**Catchment Management
Authority**
Hunter-Central Rivers

File: LVDA088
Your ref: MP 10_0215
Our ref: A807111

**Subject: Exhibition of Environmental Assessment for Port Waratah Coal
Services Terminal 4 Project (MP10_0125)**

23 April 2012

FIGURE 6.1
Vegetation Communities

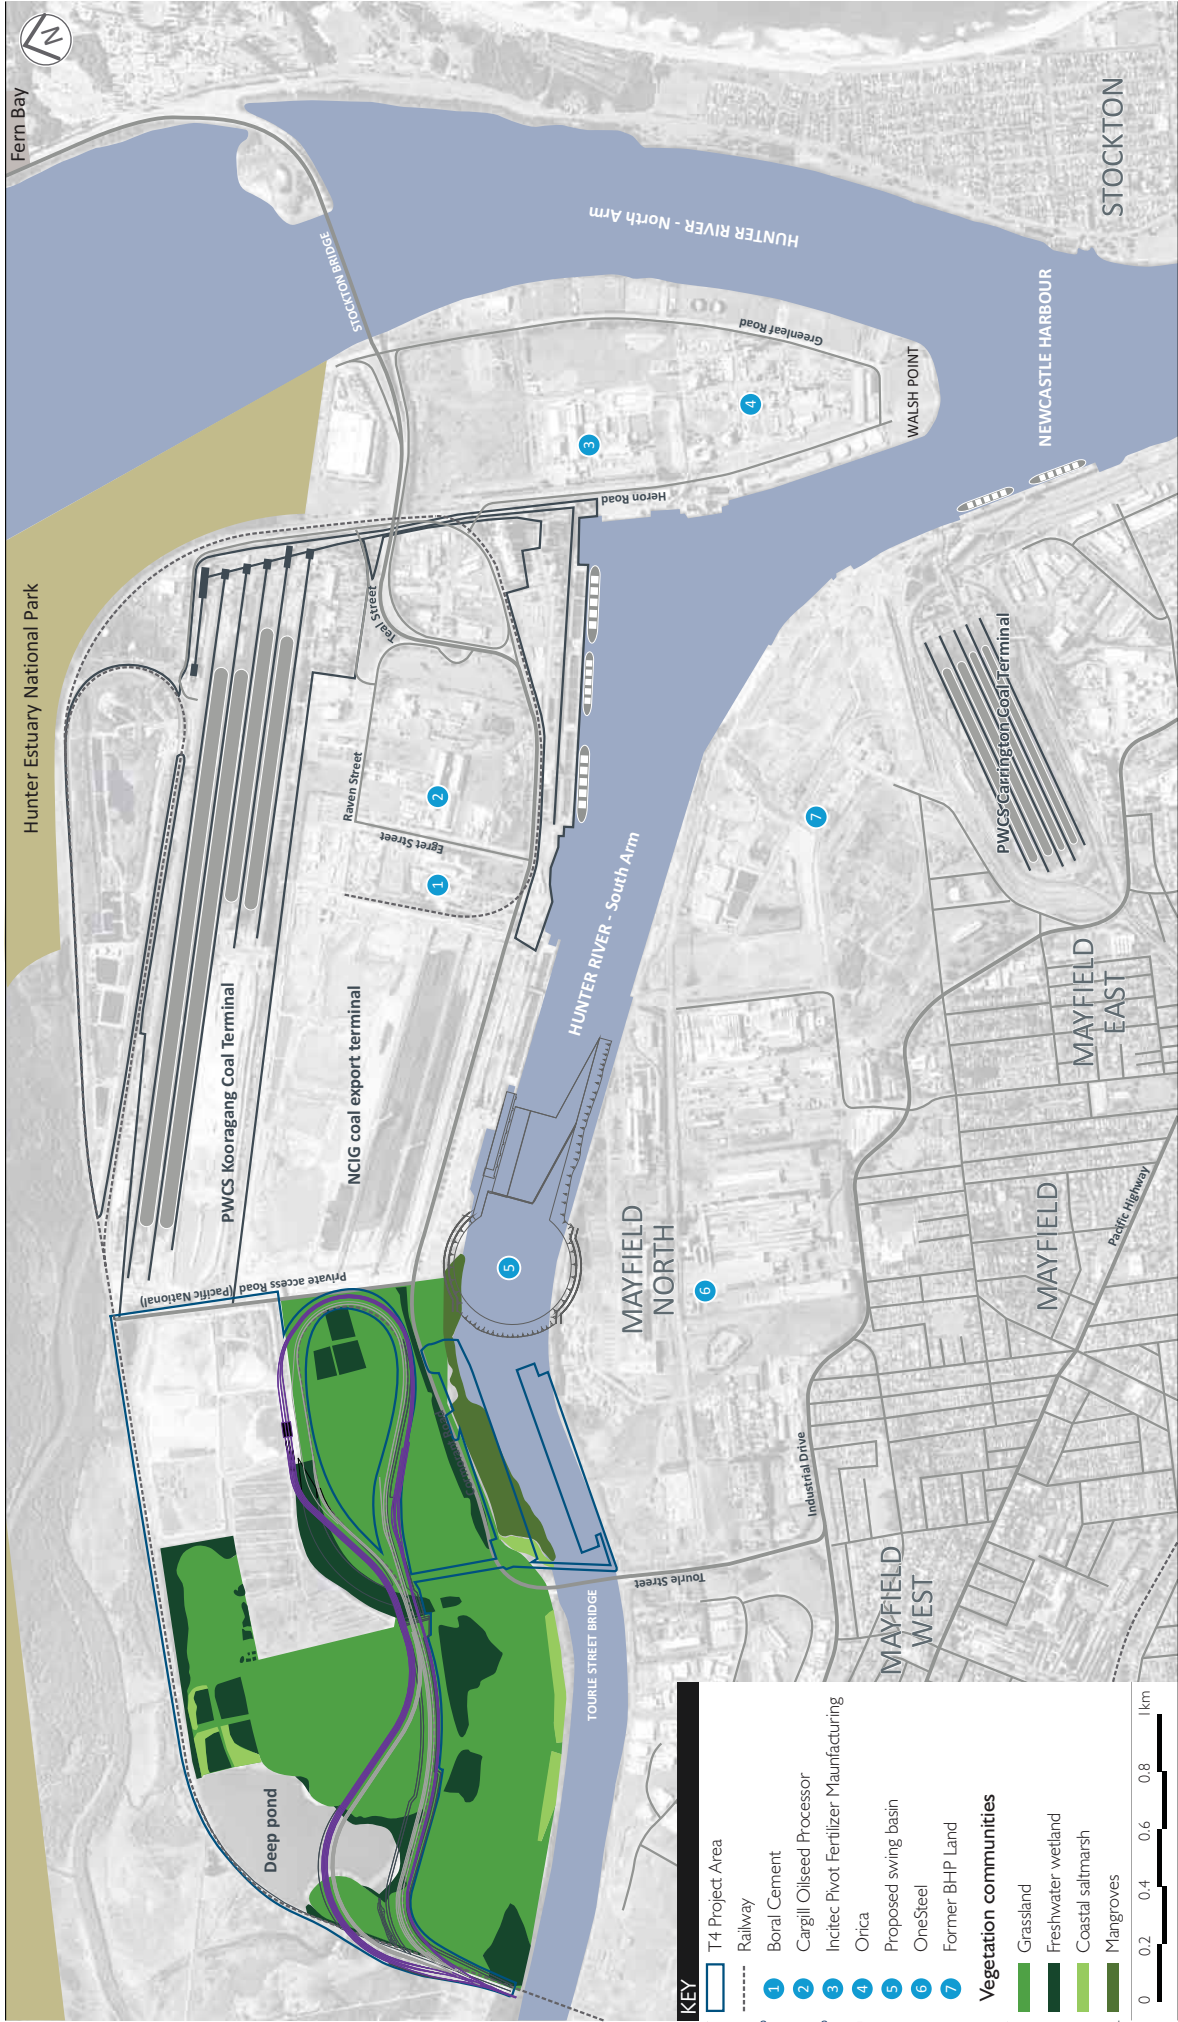
The CMA notes that the proposal will result in the removal of approximately 87ha of native vegetation including Endangered Ecological Communities (EECs) and significant habitat for Threatened Species (TS) and migratory birds.

- 28.9ha of mangroves, 27.3ha of fresh water wetlands (including 4ha of EEC freshwater wetlands), 7.5ha of mud flat habitat, 5.1ha of Green and Golden Bell Frog (GGBF) habitat and 18.8ha of saltmarsh EEC.
- loss of habitat for 14 threatened bird species including the Australasian Bittern (endangered under the TSC Act and the EPBC Act);
- loss of habitat for 7 vulnerable species of micro-bat and the vulnerable grey-headed flying fox;
- loss of the aquatic plant *Zannichellia palustris*; and
- loss of migratory and marine habitat with 84 migratory and marine species recorded in the T4 project area of which 27 species are listed under International conventions;

For example, the CMA considers Deep Pond a very important fresh water wetland within the lower Hunter estuarine complex as it sustains large numbers of migratory birds and provides a drought refuge for a range of local and regional birds, including threatened species. The unique location of this fresh water habitat within the lower Hunter estuary, and in close proximity to RAMSAR wetlands makes it a challenging site to replicate in terms of providing 'like for like' compensatory offset.
